PERMIT NUMBER
BRES2505-0077

Description: **Change exist screened porch to a sunroom**

Parcel No: **0506-72-7222.000** Site Address: **230 HEATHER BROOK CIR SPRING LAKE, NC 28390**

DRAWINGS

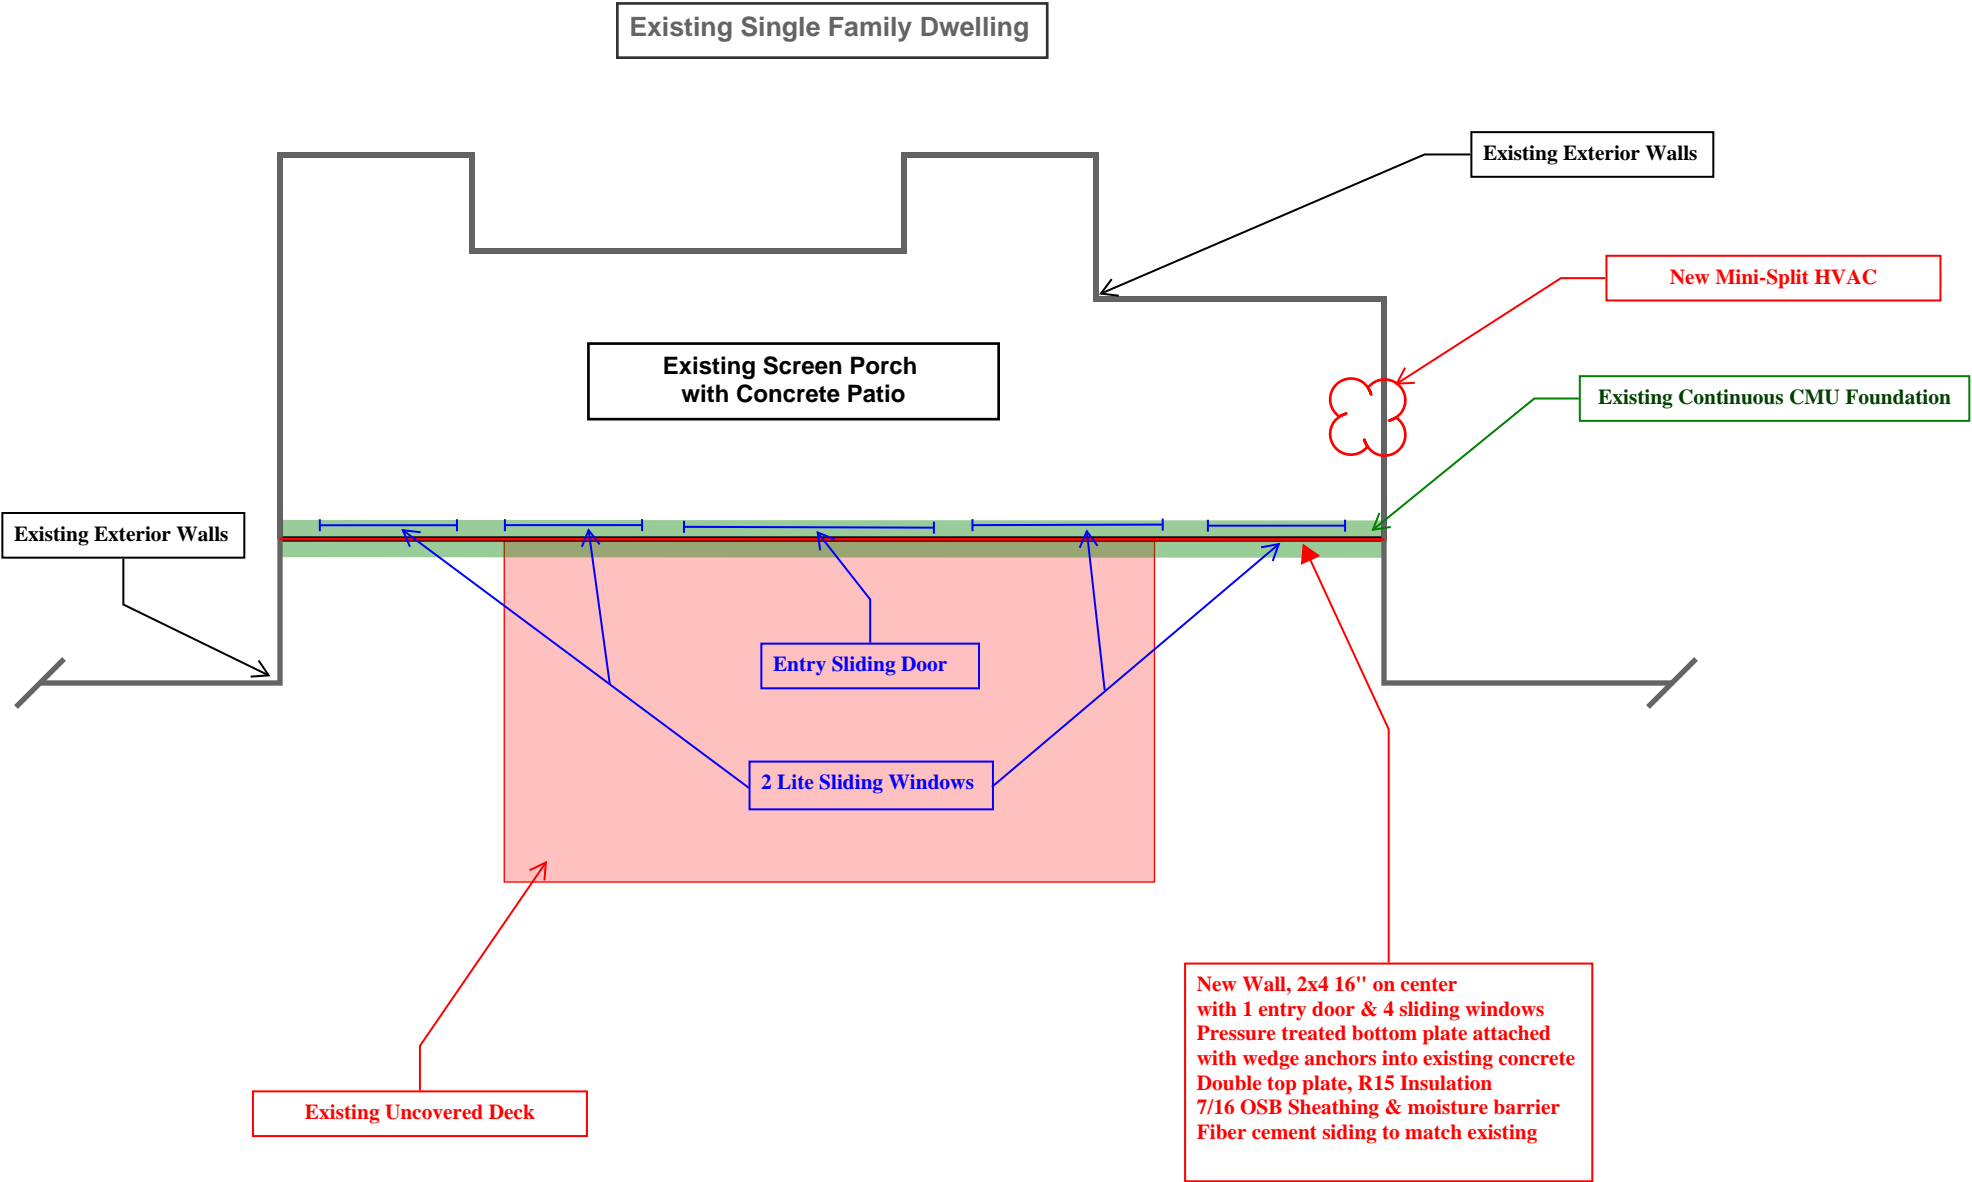
REVIEW TYPE	REVIEWER	SENT DATE	DUE DATE	RETURNED DATE	STATUS	REMARKS	NOTES
CENTRAL PERMITTING INTAKE	CP Bucket	5/22/2025	5/23/2025	5/22/2025	APPROVED		
RESIDENTIAL BUILDING	Brad Sutton	5/22/2025	5/28/2025	5/29/2025	DISAPPROVED	in attach	Verify no bedroom egress windows will be enclosed by this conversion, make a note on the plan, and sign and date whoever makes the note.
RESIDENTIAL BUILDING	Brad Sutton	5/29/2025	6/3/2025	6/2/2025	APPROVED	in attachments
